**RE: Bradley Heights PUD Development Plan – Third Review Comments File # AR PUD 21-00206**

The proposed project involves a PUD development plan to enable development of a vacant parcel into 168 single-family residences. Staff finds that the application is largely acceptable; however, the following technical modifications must be completed.

SHEET CV 1

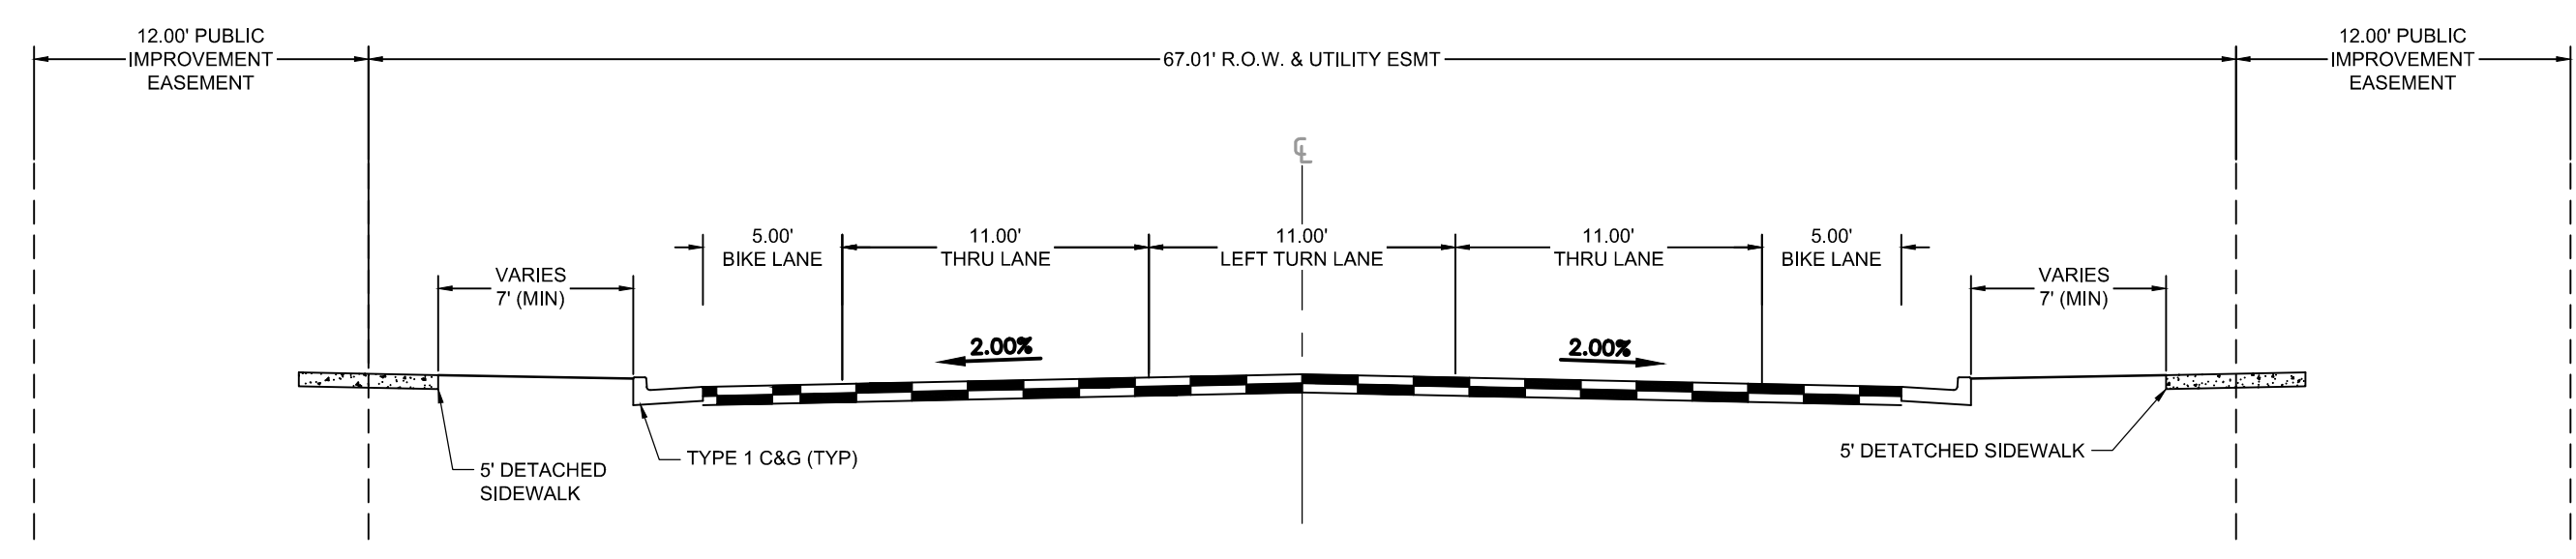
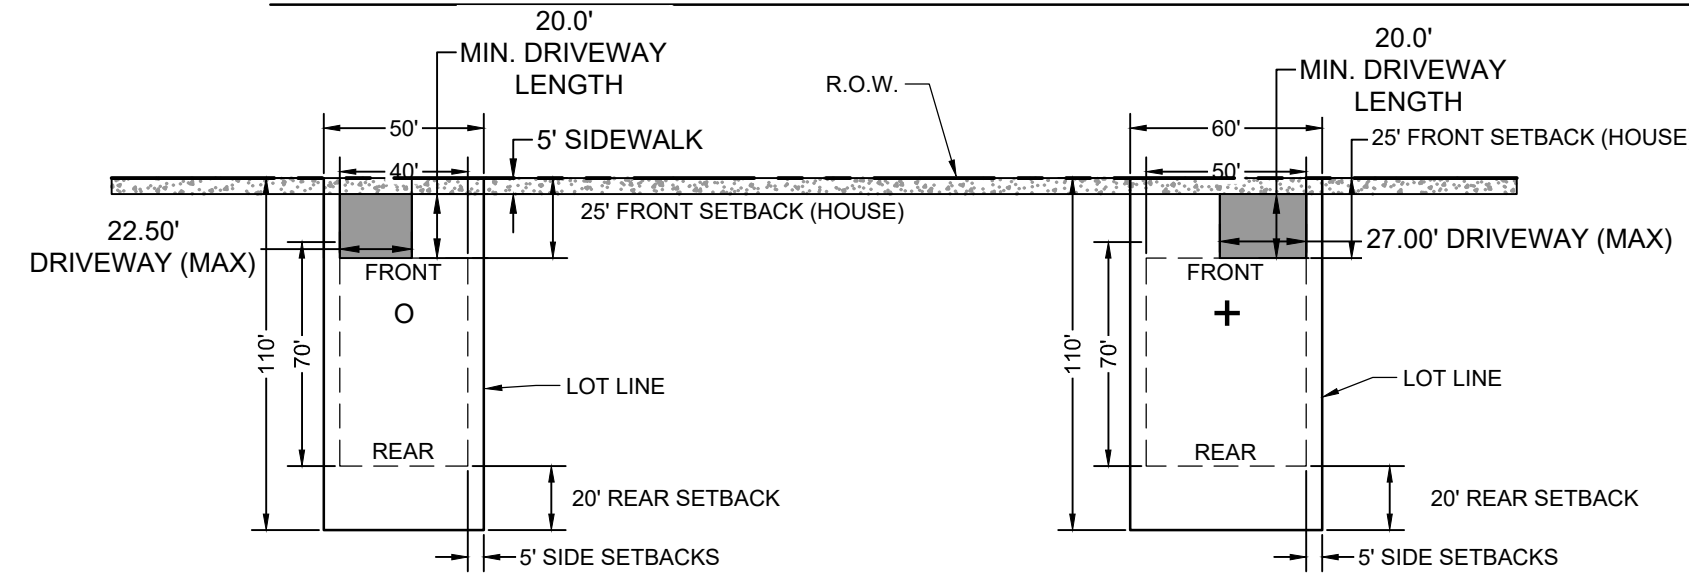
- New comment: please add a table on the cover sheet to demonstrate parking spaces provided, and whether the spaces are in the private garages, in driveways, or on-street. Also call out the driveway width for lot typicals (50-foot-wide vs. 60-foot-wide lots) and whether one-car or two-car garages are to be provided with the homes.**

**STAFF 3<sup>rd</sup> REVIEW COMMENT:** Partially addressed. Small-lot PUD guidelines do have standards for guest parking. Since many of the lots in this proposed development meet the 6,000 square-foot lot size or less, these guidelines apply to those units. Please indicate in a table and/or other graphic illustration where the guest parking spaces will be located, and how many spaces are provided compared to how many of the lots are less than 6,000 square feet.

**Applicant response:** "The following note 19 has been added to the cover sheet: 19. TYPICAL HOMES WILL HAVE TWO-CAR GARAGES WITH DRIVEWAY WIDTHS AND LENGTHS SUFFICIENT FOR THE PARKING OF TWO VEHICLES. The driveway lengths and widths have been called out on the lot typicals. It is our understanding that there is no specific parking requirement for typical single family lots thus a parking table has not been added. Sufficient areas for parking are provided in garages, driveways and on streets (where no restricted for emergency access,"

CHALLENGER HOMES
 PUD DEVELOPMENT PLAN
 OVERALL SITE DISTANCE & PHASING PLAN
 SHEET **OV** 4

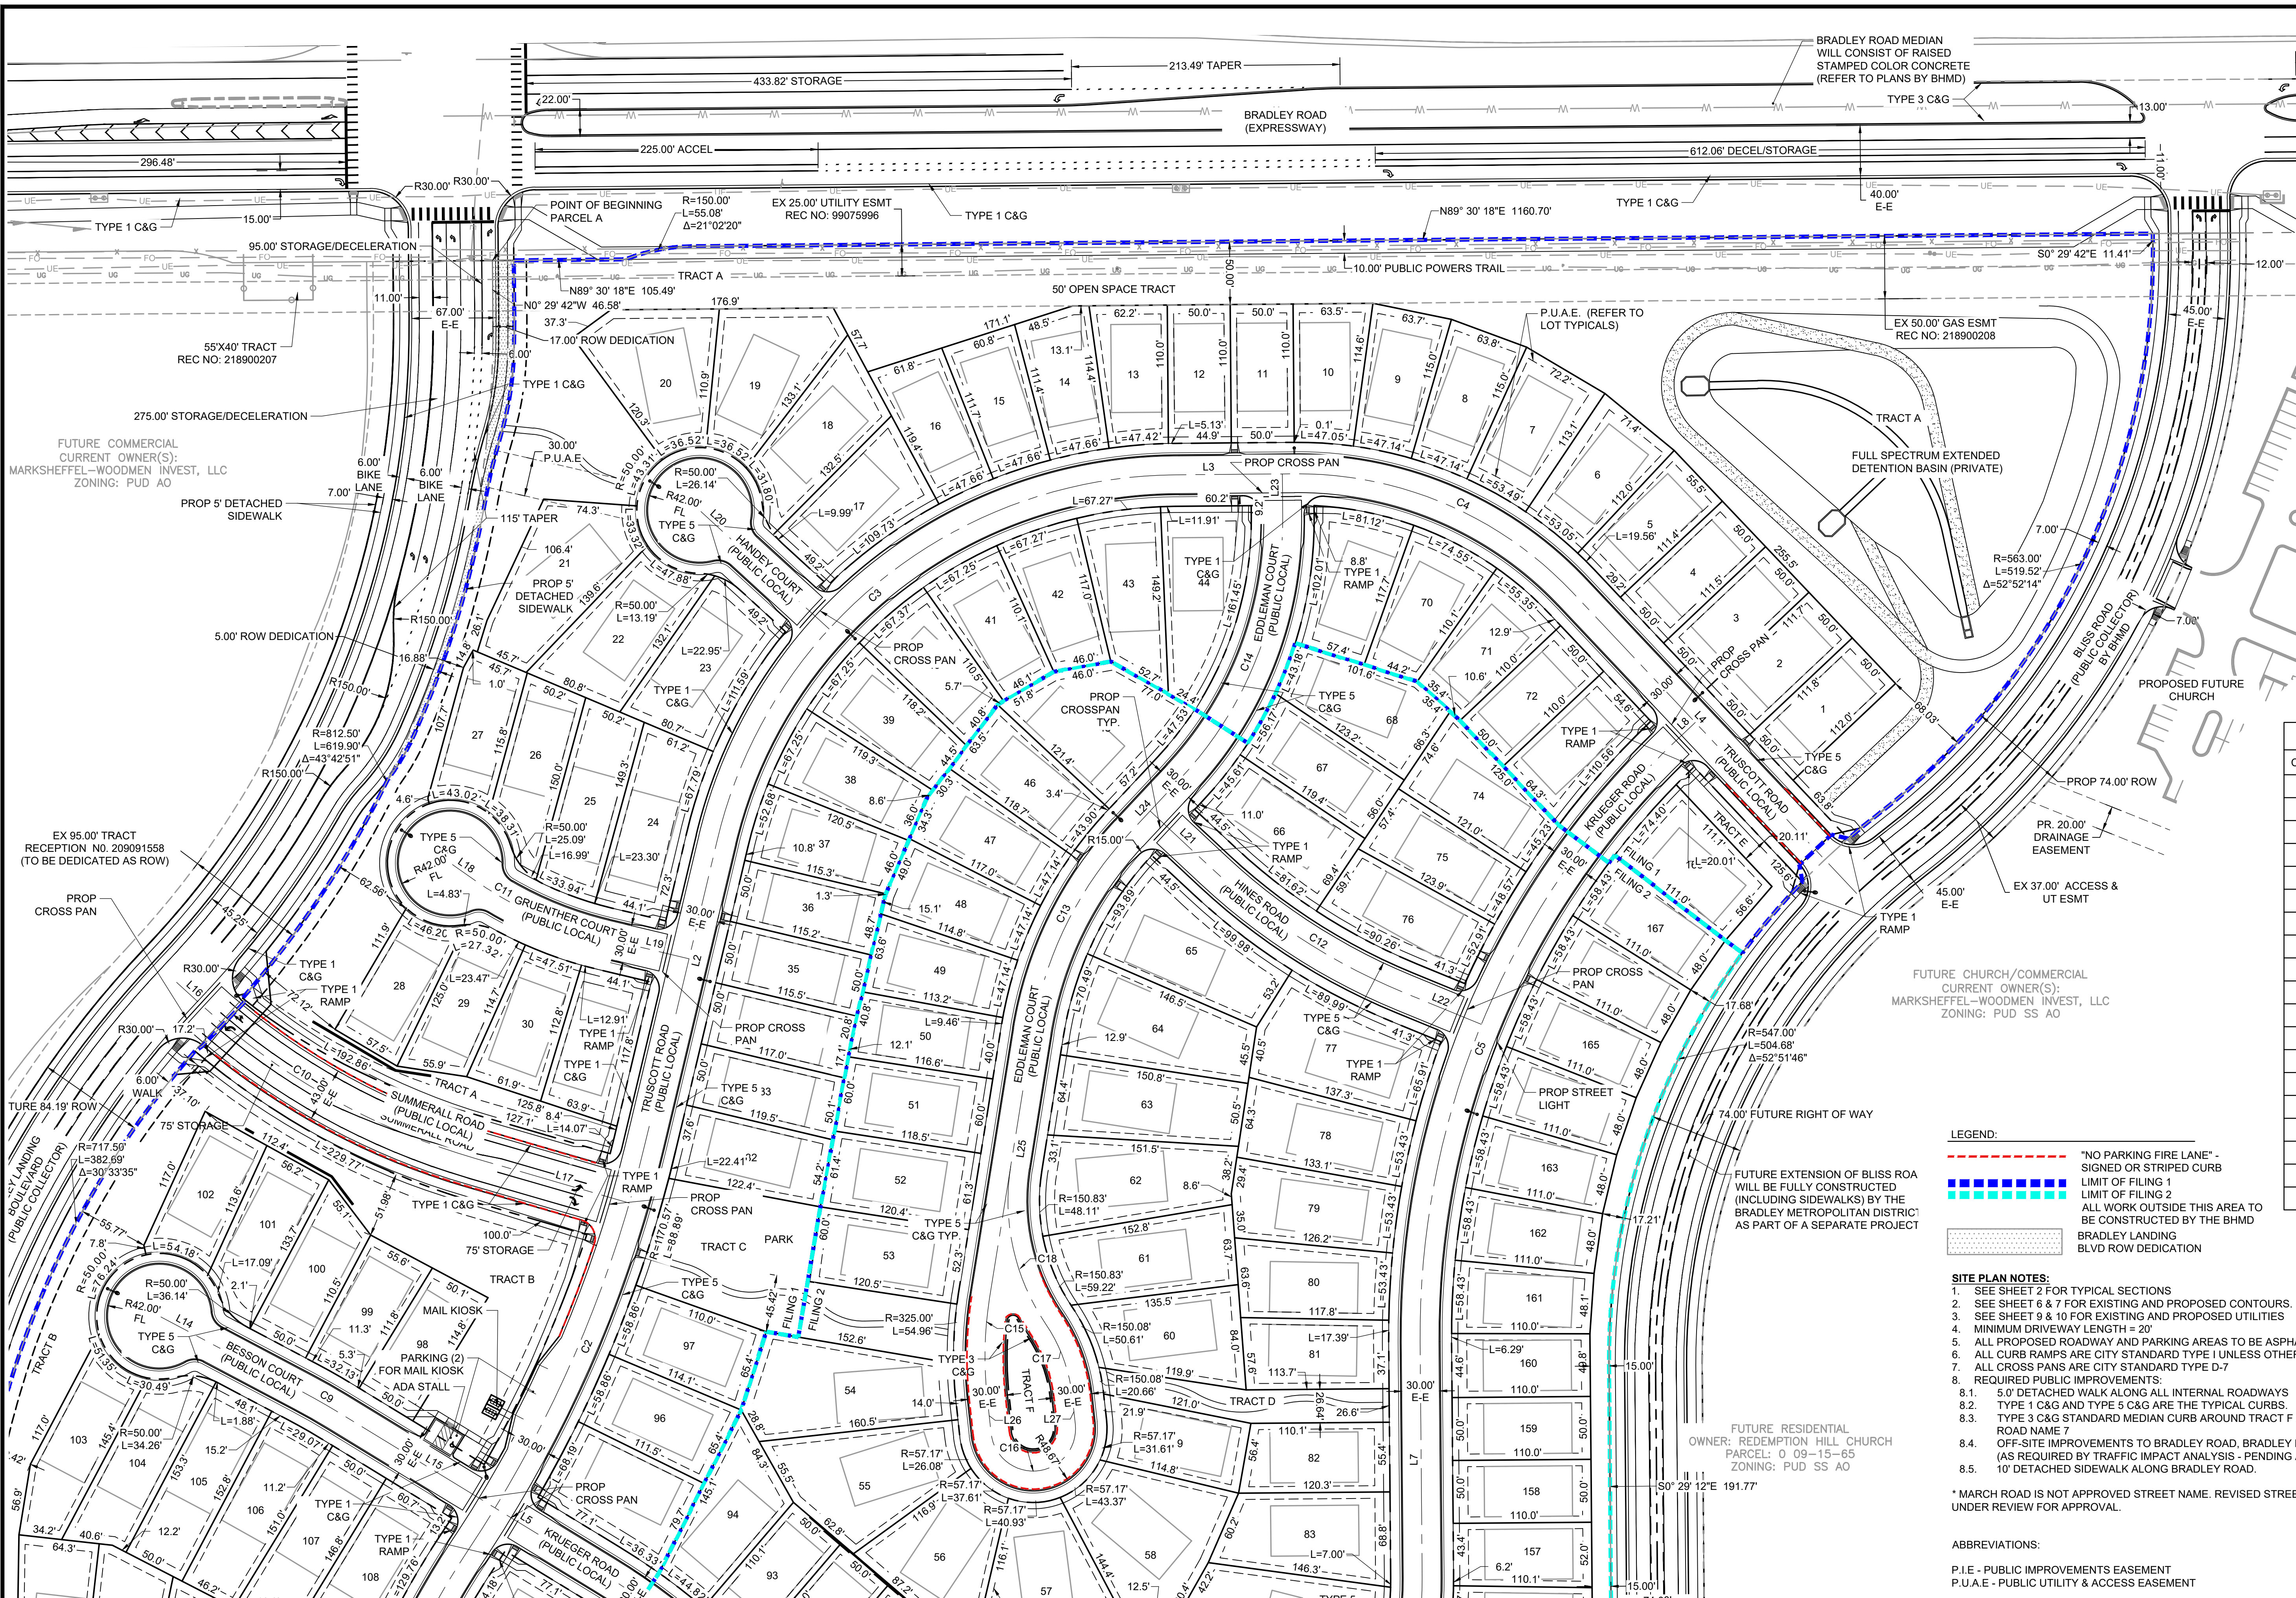
.. Repeat Comment: Label detention facility as "Full Spectrum Extended Detention Basin" and state whether it is public or private. Update: Sheet 4 does not include "Private".

PUD DEVELOPMENT PLAN
PUBLIC UTILITY & FACILITY PLAN - NORTH

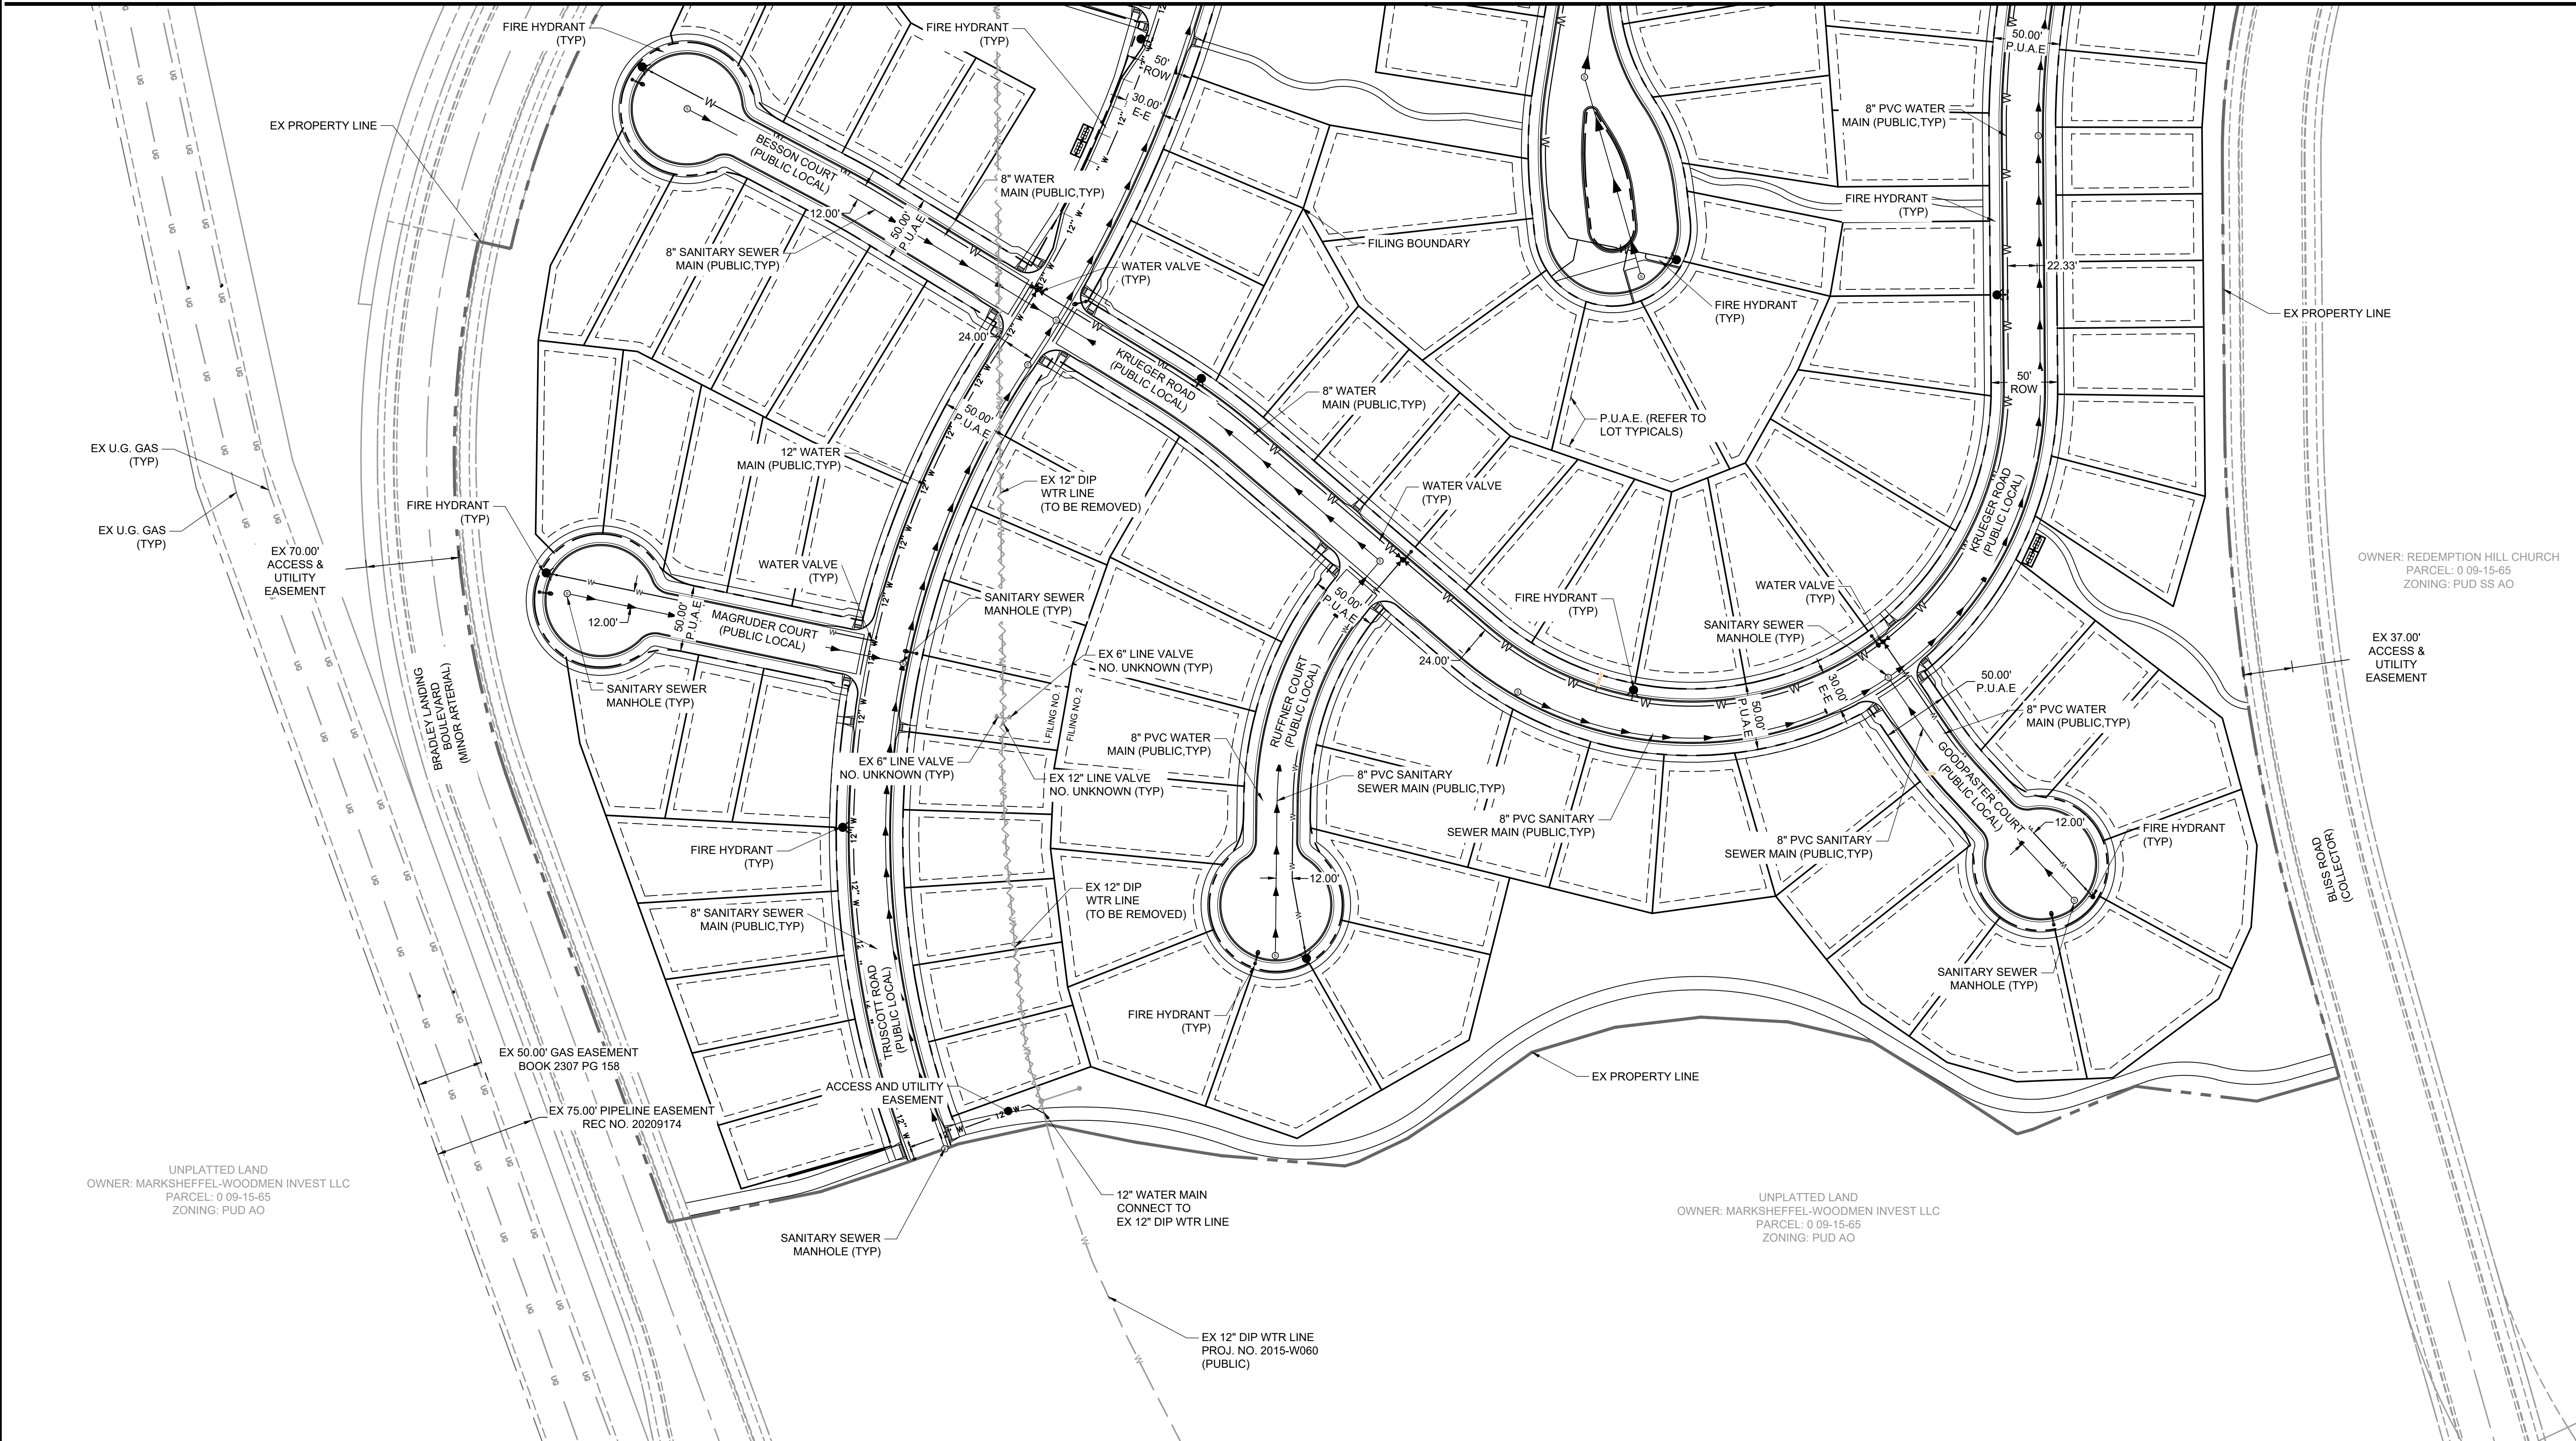
1. Please call out on the utility plan which utilities are CSU, and which utilities are Centre within Bradley Road.
2. What does the dark blue dashed line mean on your utility drawing? Please show this in a legend and call out on plan.
3. Please give me a call to discuss your proposed grading plan as well as the PRV per the HGL at 719-668-8769 Al
4. If the water and wastewater services are to be serviced from Centre Metropolitan District for water and wastewater then why do we need to show the city cross section that you added to you plan.

1. You propose a new wastewater main within Bradley Rd, and it looks like it is feeding from the west, and it connects to the proposed CSU wastewater main for this development. Where is this line coming from and who owns this line.?

2. Proposed manholes cannot be within the curb and gutter pan.
3. You will need to design the proposed utilities to the current cross section standards. Please reference the criteria at [www.csu.org](http://www.csu.org). If you have any questions, you can reach out to me at [ajuvera@csu.org](mailto:ajuvera@csu.org)

4. Make sure you call out and show all retaining walls on the utility plan.
5. You will need to show the lot numbers on the utility plan.
6. You will need to show the current cross section on the utility plan for each proposed right of way where you propose utilities.

7. You will need to revise the water main alignment for this project in reference to your meeting with Bill Davis from CSU on the next review submittal.

8. You only need to show the service criteria detail on the construction plan detail. Remove off the utility plan.
9. Call out a note on both side of your plan that you are connecting to the future 24-inch water main.

10. Some of the text is missing on the top of your utility plan that call out the existing wastewater main.
11. How are you tying into the existing wastewater main in Bradley Rd? Call this information out on the plan view.

12. The proposed storm within Bradley Road will need to be 10 feet off of the 24-inch water main.
13. Two PRV is required where you connect to the 24- inch water line one at Bradley Landing and the other at Bliss Road.

14. The proposed future CSU water main within Bradley Landing is way too close to the curb and gutter. All cross sections are required to show on the plan, and they need to be the current cross sections with CSU standards.

15. We don't need this connection to the existing 12 water line on the south portion of your site. Please remove off drawing.
16. Reference drawing some of the street name text is covering up proposed manholes.

17. The proposed sewer cannot go through the island area.
18. Add a vicinity map to the utility plan sheet.
19. Add the CSU Preliminary general notes to the utility plan.
